# **Dogger Bank South Offshore Wind Farms**

**Environmental Statement**

**Appendix 10-1 Fish and Shellfish Ecology Consultation  
Responses**

**June 2024**

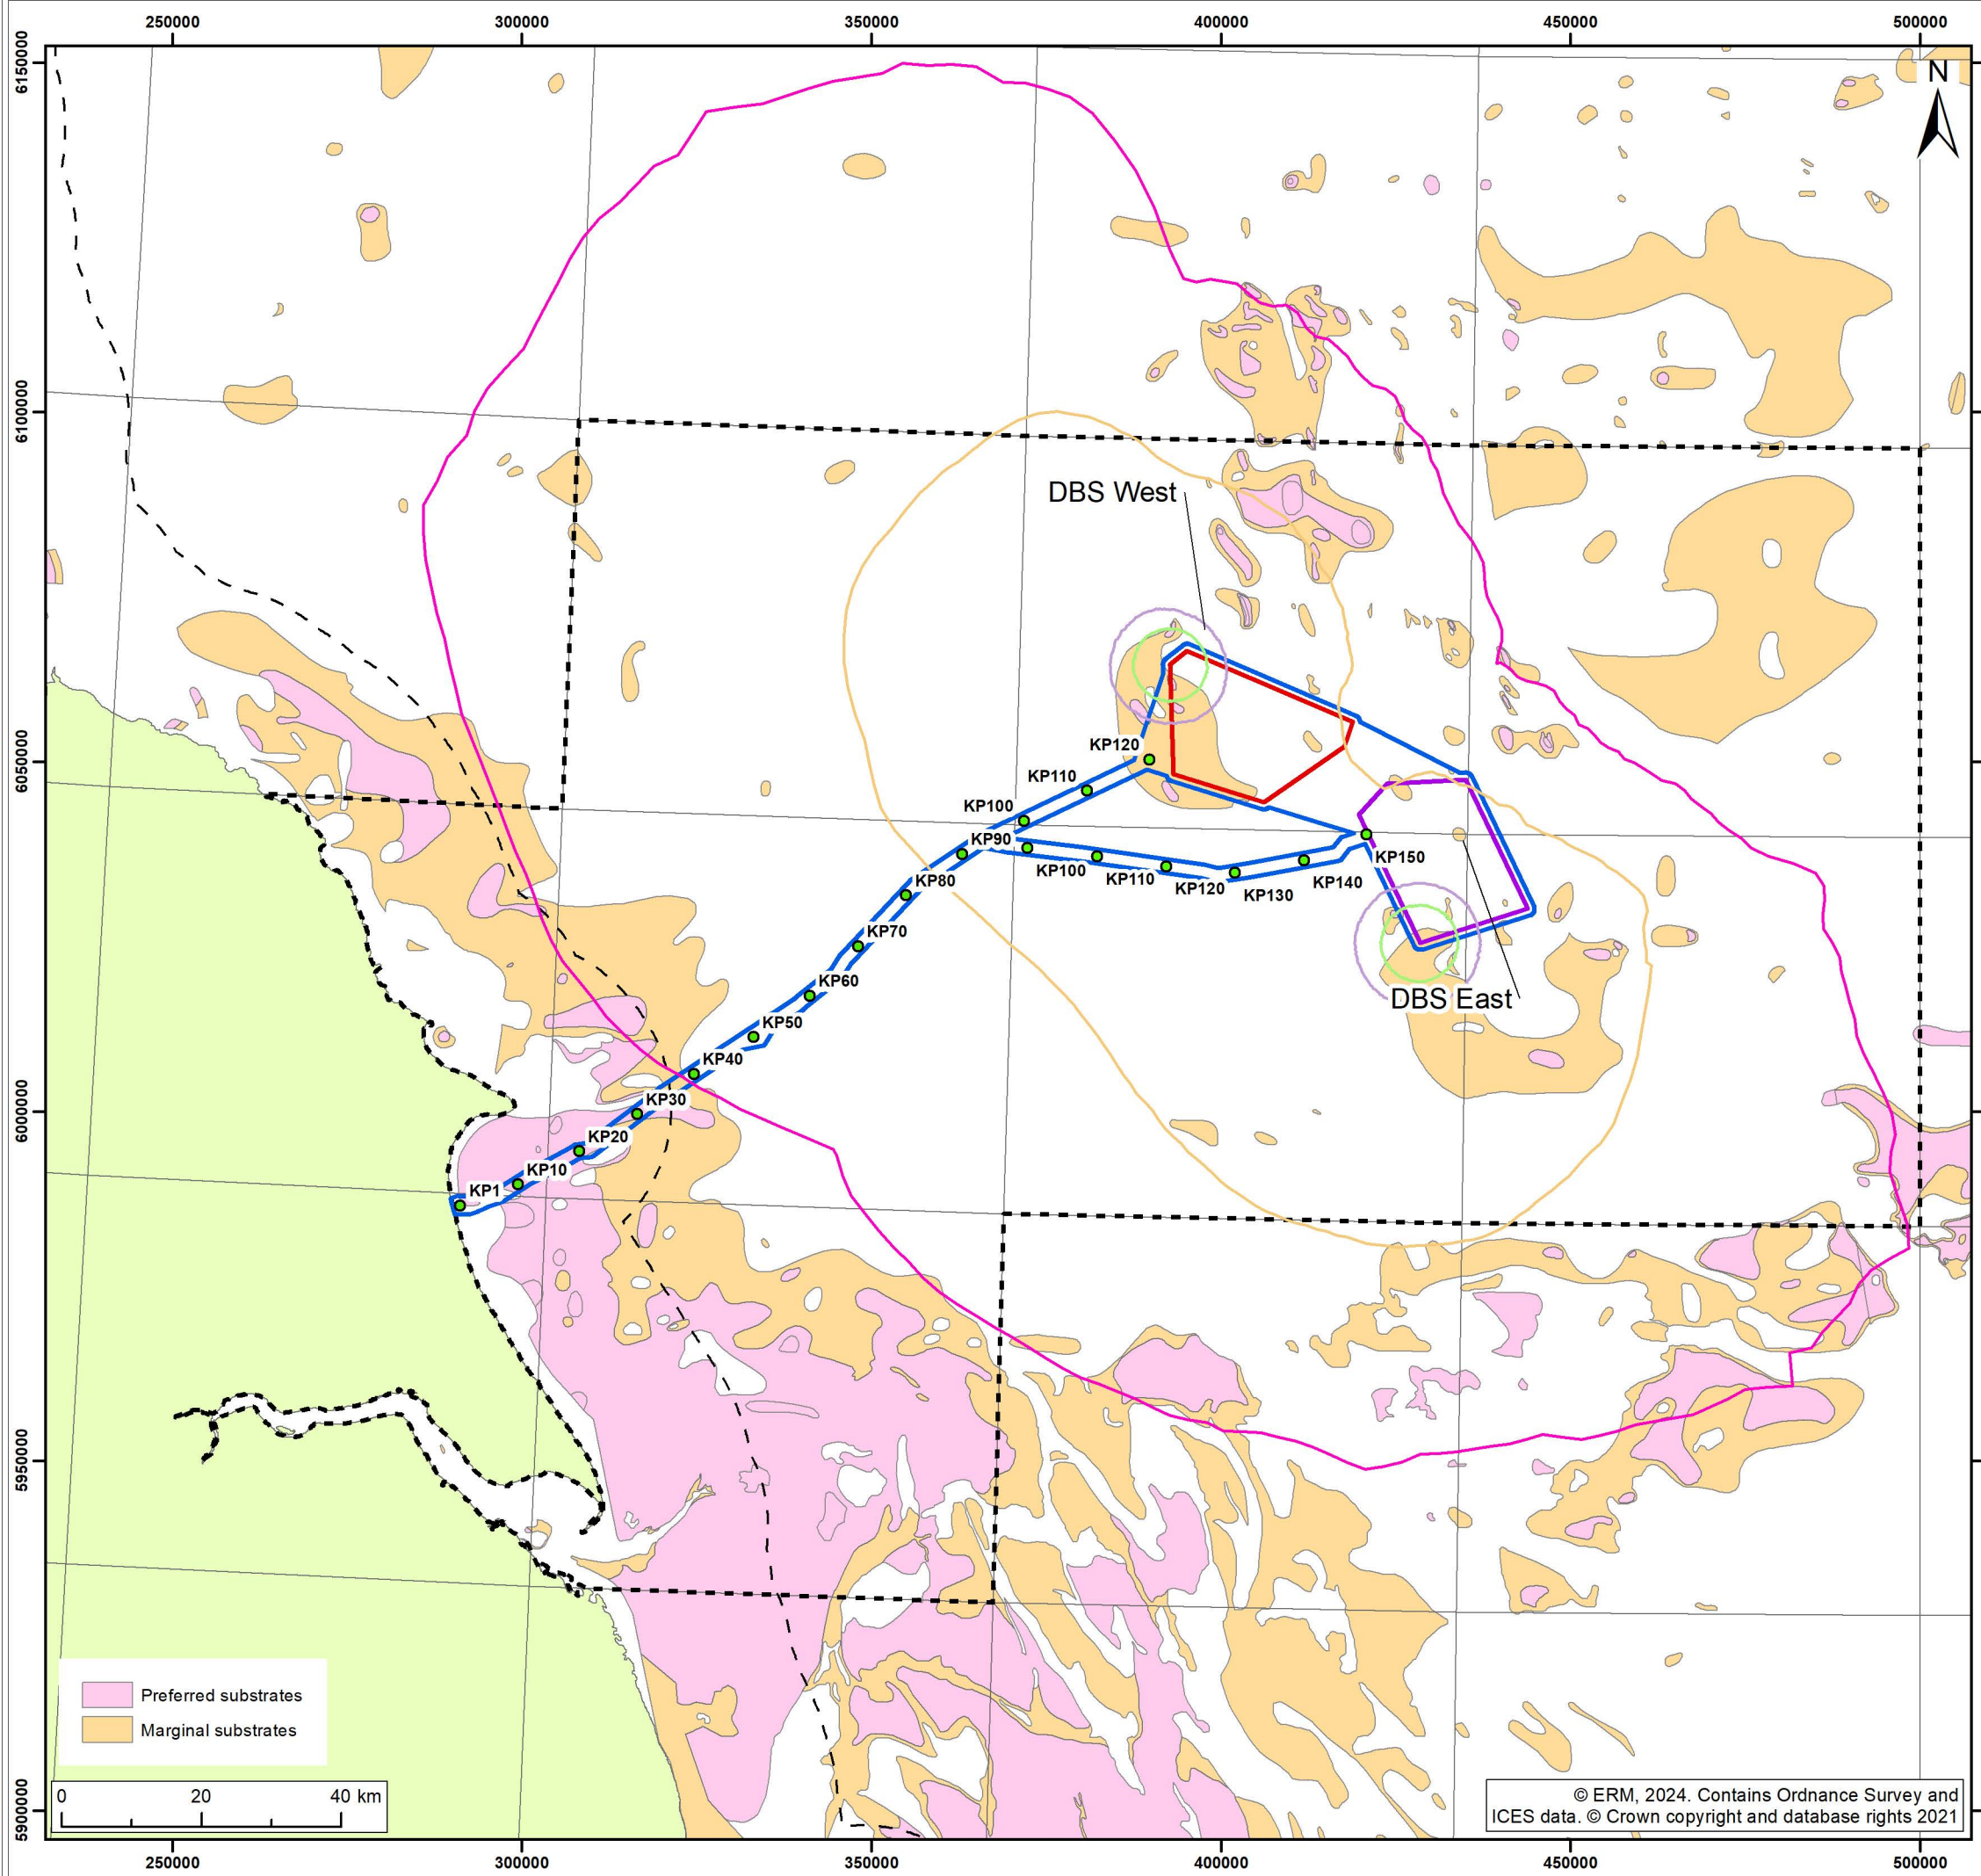
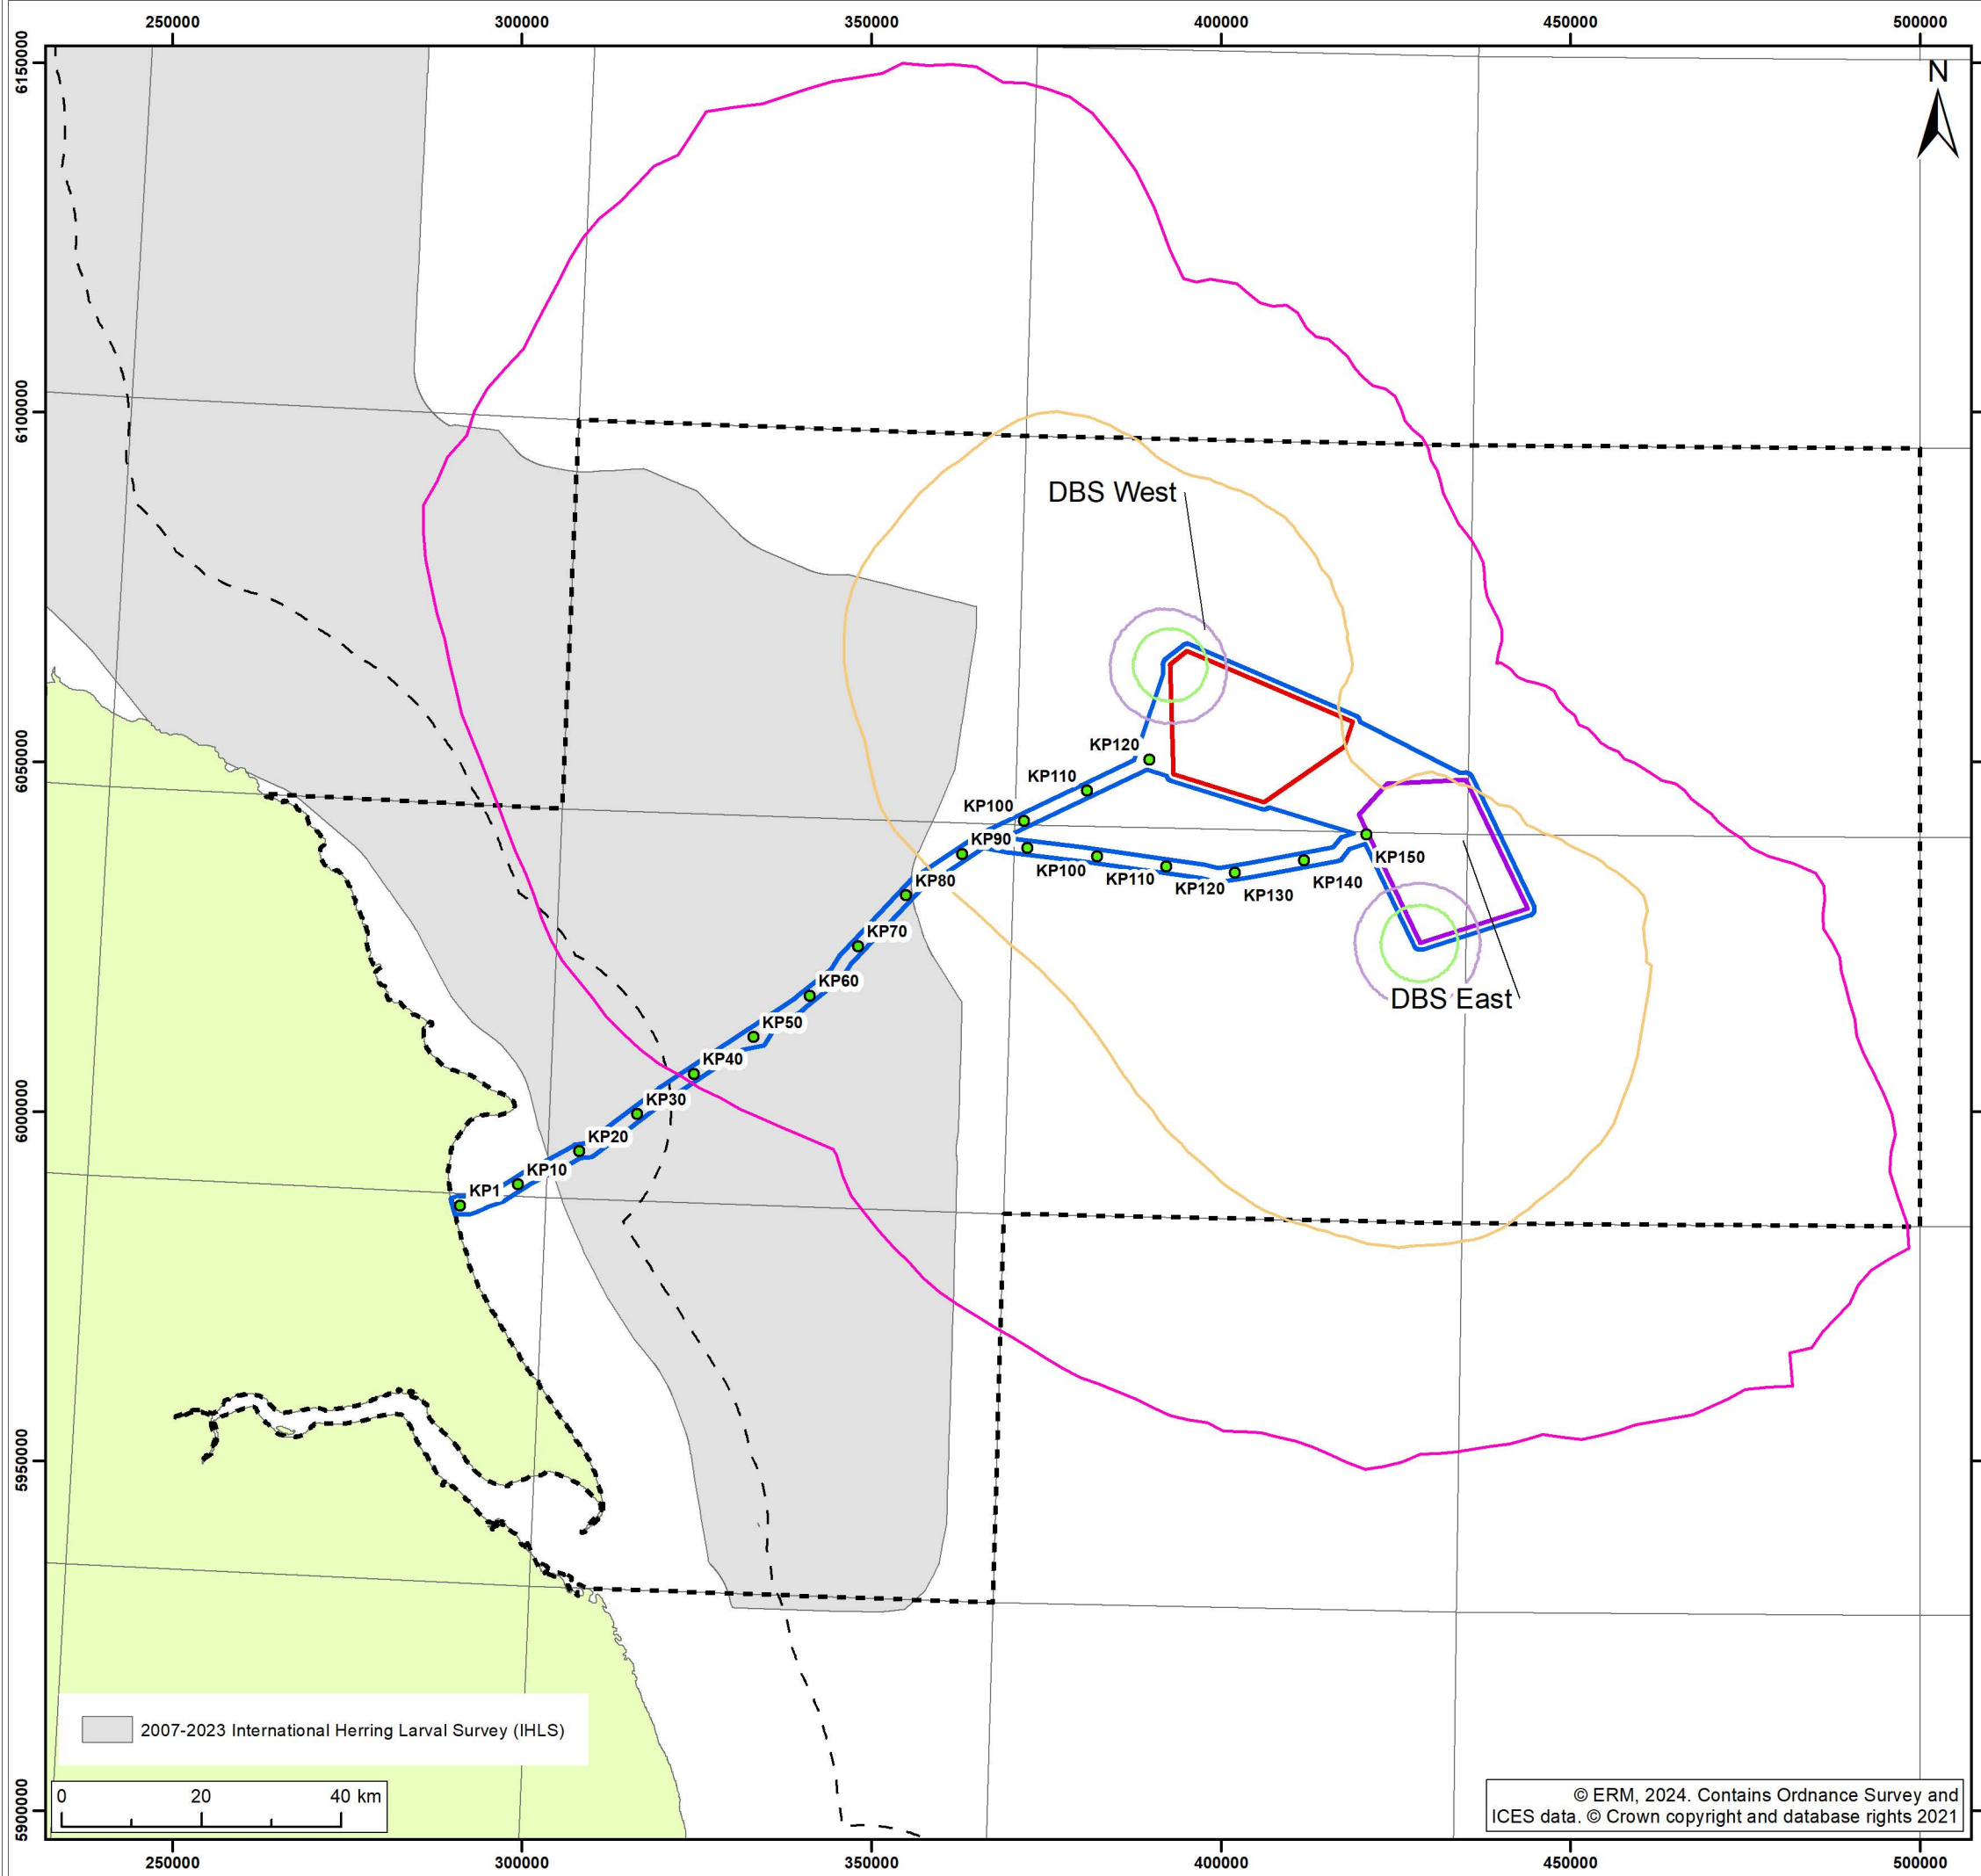
Comment	Project Response
commercially important fishes. The JNCC 1995a and 1995b citations were not included in the reference list for review and comment.	
The MMO notes that herring spawning grounds have not been depicted in Figure 2-11, only their nursery grounds have been mapped. Nonetheless, section 263 acknowledges that Atlantic herring have spawning grounds within the Projects' study area and that the species is highly sensitive to changes in their substrate composition. The MMO note that potential herring spawning habitat has been mapped further on in Figure 2-14, following the method described by MarineSpace (2013a) which the MMO support.	Spawning and nursery grounds of Atlantic herring as determined within Coull <i>et al.</i> (1998), and Ellis <i>et al.</i> (2012) are depicted within <b>Volume 7, Figure 10-6 (application ref: 7.10.1)</b> . Potential Atlantic herring spawning grounds are depicted in <b>Volume 7, Figure 10-7 (application ref: 7.10.1)</b> , following the methodology described within Reach <i>et al.</i> (2013).
